Online Comment

Application H23-0761-17
Location High Road Whaplode Spalding PE12 6TG
Proposal Residential development comprising 33 dwellings - approved under H23-0508-16. Modification of Condition 2 to allow amendments to previously approved plans

Name Glen Chapman
Address Environmental Services

Date Submitted 20-02-18
For/Against Comments

Drawing Title:
Proposed Site Plan

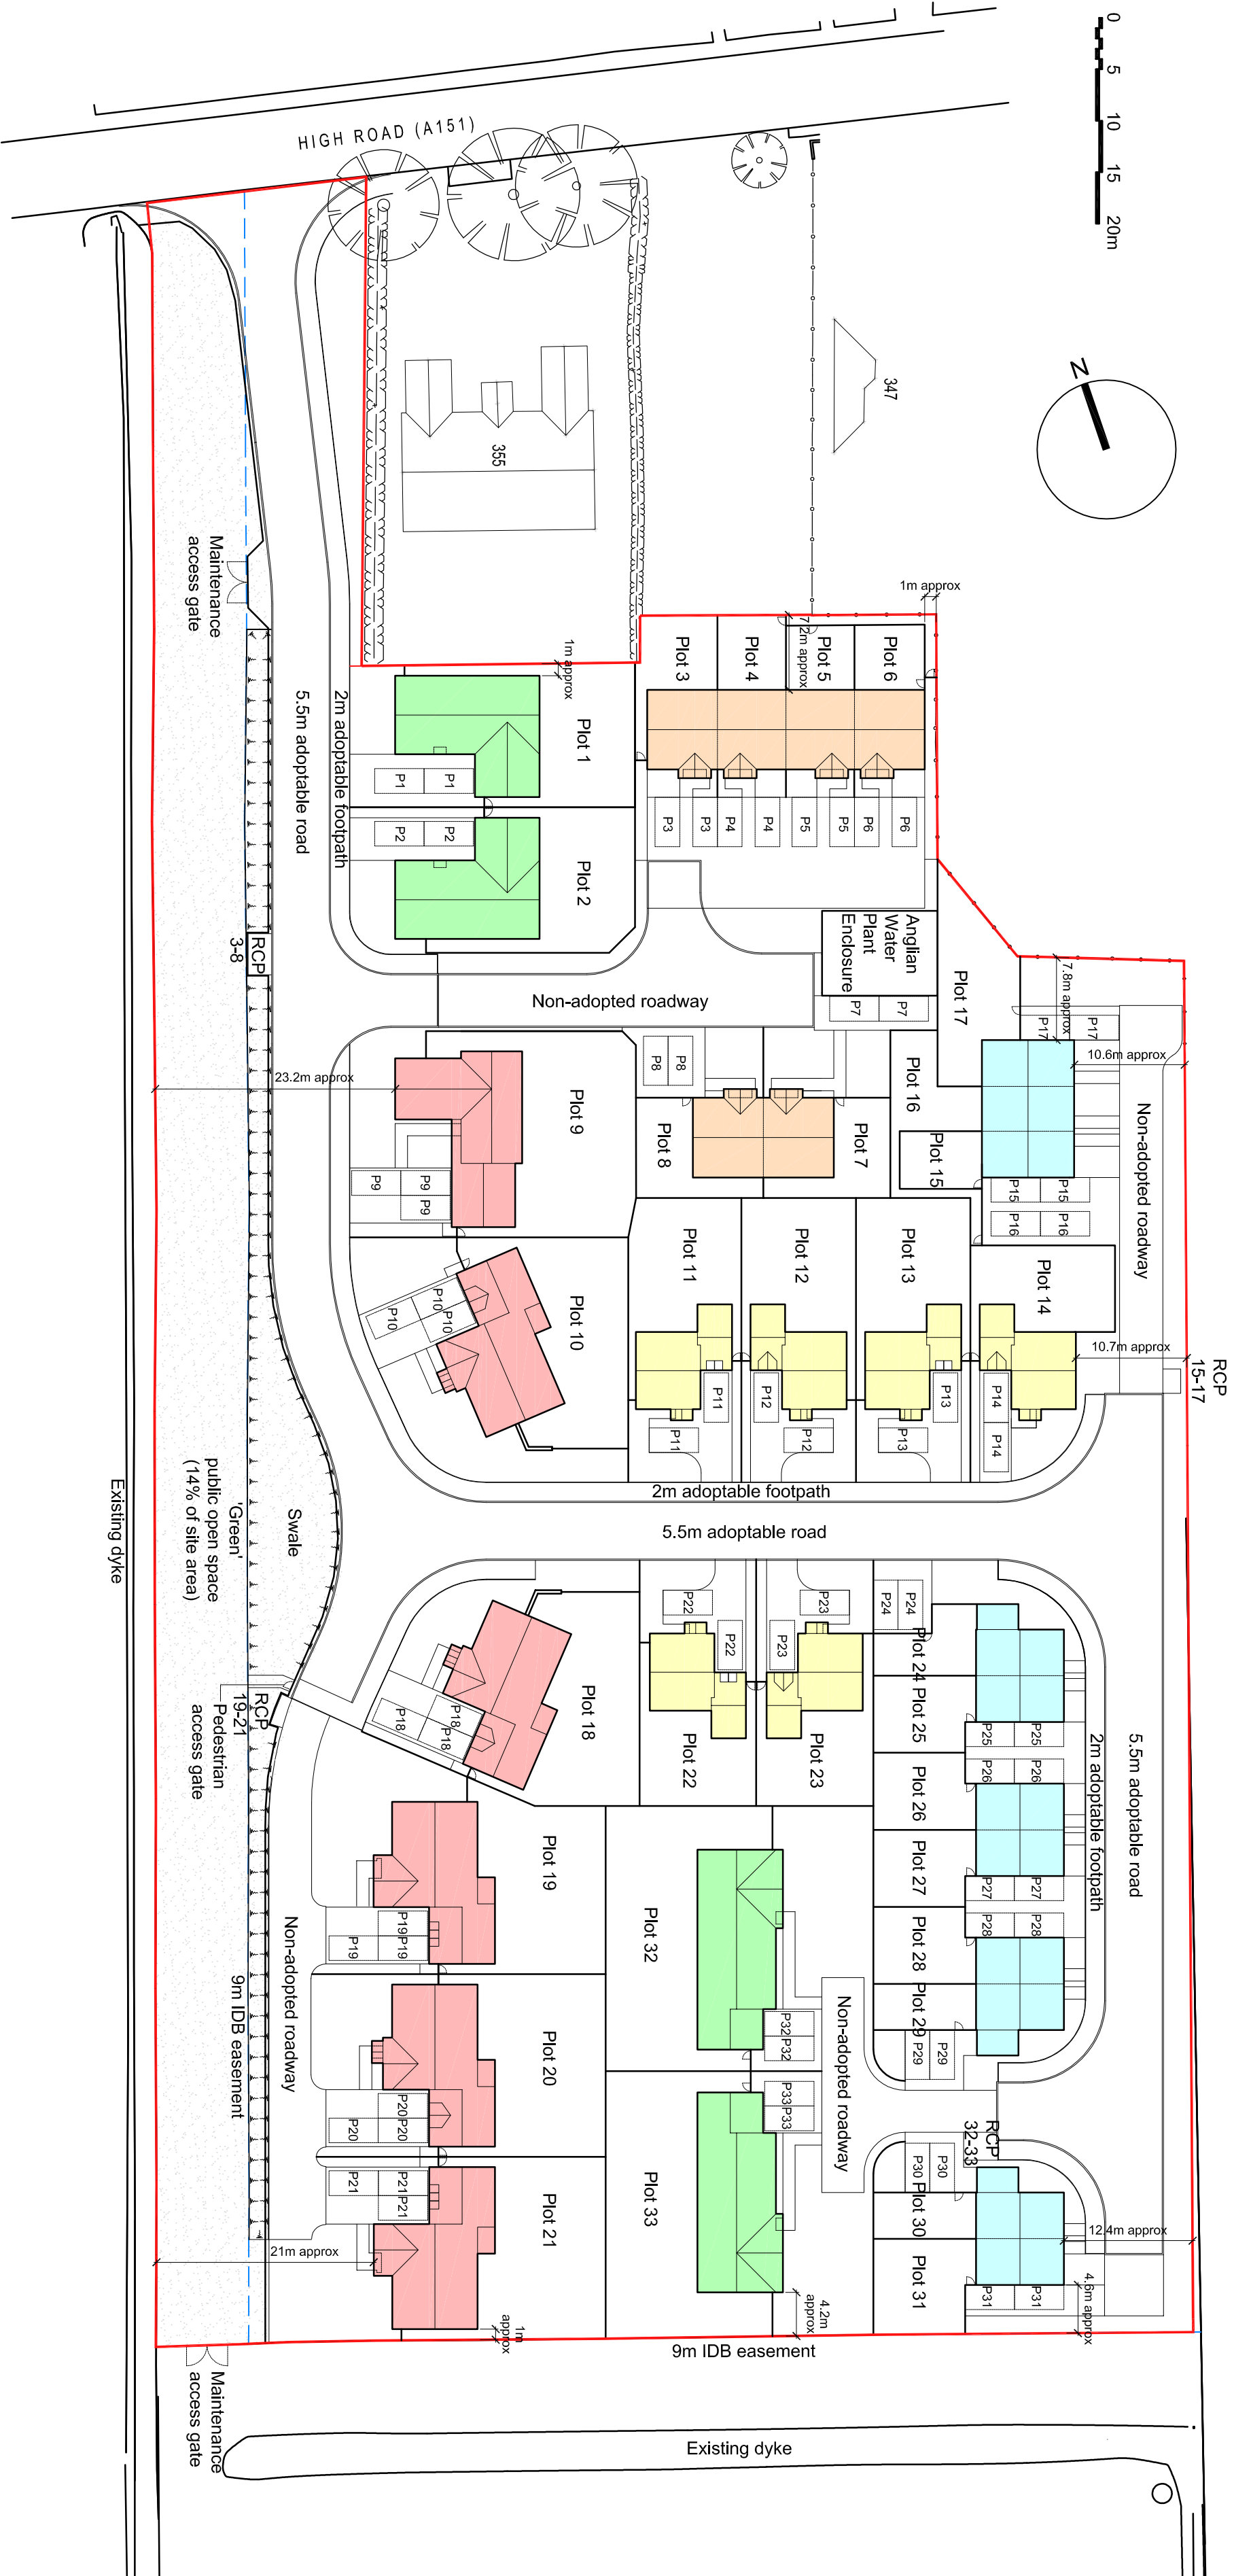
Access roadways to all residential properties should be constructed to an adoptable standard under an agreement with Lincolnshire County Council so that they will become public highways. This will enable refuse/recycling collections to be carried out from outside individual properties without the need for communal collection points at the point where private driveways adjoin public highways.

If not utilised correctly communal collection points become areas of dispute for residents of adjacent properties.

Should it be agreed that communal collection points will form part of this development the position of those collection points should be made clear to the potential occupiers of the properties nearby. This should not just be to the properties that will need to use the collection points but also the ones who will have them outside their properties.

In respect to this application plots 3, 4, 5, 6, 7 and 8 will need to present adjacent to plots 2 and 9; Plots 15, 16 and 17 will need to present adjacent to plot 14; plots 19, 20 and 21 will need to present adjacent to plot 18; plots 32 and 33 will need to present adjacent plots 29 and 30.
